Topic	PF Response																											
WSCC commence dated 10 th May 2022																												
Cycle track width to be widened to provide for two-way flows on both sides of the new road	Our design currently has a 2m cycleway either side alongside the footway which in accordance with LTN 1/20 allows for a maximum of flow of cycles at 200 per peak hour, see extract below: Table 5-2: Cycle lane and track widths

A29 Sections Key Plan

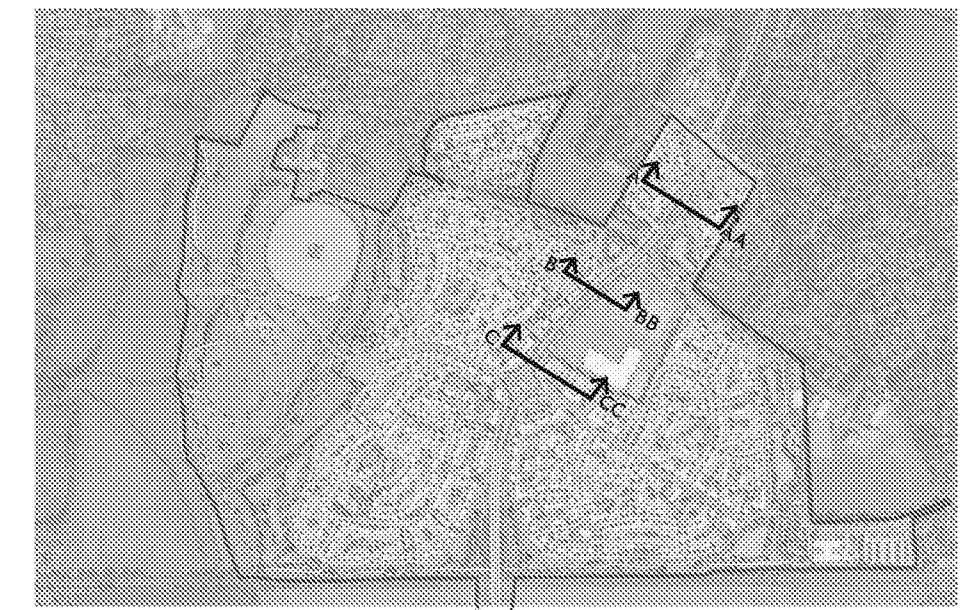
Applicant to explain rationale for ‘no kerbed’ new A29, road width of the same and what effect these might have on traffic speeds.	Not sure where this has come from as the proposed A29 is kerbed, please see below section from PF drawing A13394-PF-ZZ-XX-DR-CD-00001 P05  The diagram shows a cross-section of a road with a central carriageway and two footways. The central carriageway is flanked by PCC Kerbs, 125mm upstand. The footways are flanked by PCC Edging Kerbs. The pavement layers are as follows: - Surface Course: 45mm HRA 30/14 Surf 40/60 with 14/20mm Pre Coat chips to EN 13108-1 - Blinder Course: 60mm nominal size dense bitumen macadam - Base Course: 160mm nominal size dense bitumen macadam - Sub-Base: 150mm (Minimum) Granular sub-base material Type 1 - Surface Course: 20mm (0-6mm) Nominal size dense bitumen macadam, Contrasting asphalt to footway - Blinder Course: 60mm (0-20mm) nominal size dense bitumen macadam - Base Course: 150mm Granular sub-base material Type 1 - Physical delineation strip to be kerb or similar agreed at detailed design stage

Crossings Location Plan

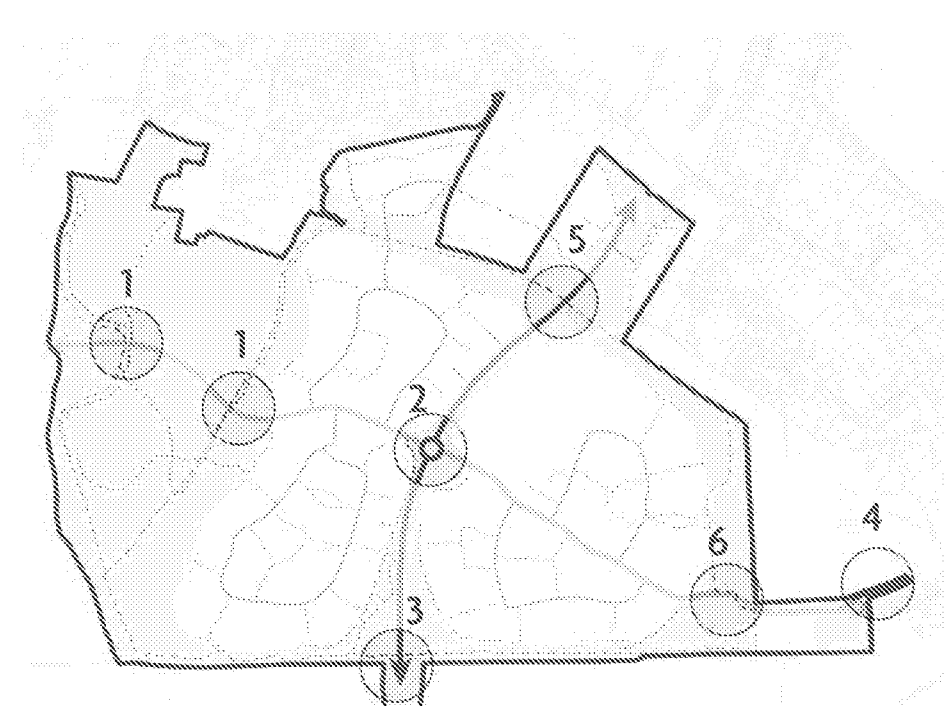
Applicant to explain the same (i.e. that set-out in point 9 above) for the proposed crossing points around the roundabouts.	In line with LTN 1/20 we have proposed Parallel ‘controlled’ crossing points around the main roundabout junction as primary links across the site. On the main A29 we have shown a refuse to protect users on the side roads the length of crossing is reduced. Providing a parallel crossing aligns with the segregated nature of the main routes and allows for continued use of the links on both sides of the proposed A29.
Speed limit reduction on approaches to new road and associated links (on existing A29) – what evidence of data collection and information consultation has been carried out?	No, we do not currently have any speed surveys. It is appreciated that the road is currently shown as a 50mph speed limit but because of the nature of the road, surrounding elements and Lidsey Bends to the north actual speeds are closer to 30mph. Aligned with the true speed of the road and our proposed junction arrangements we suggest that 30mph be implemented in this location.
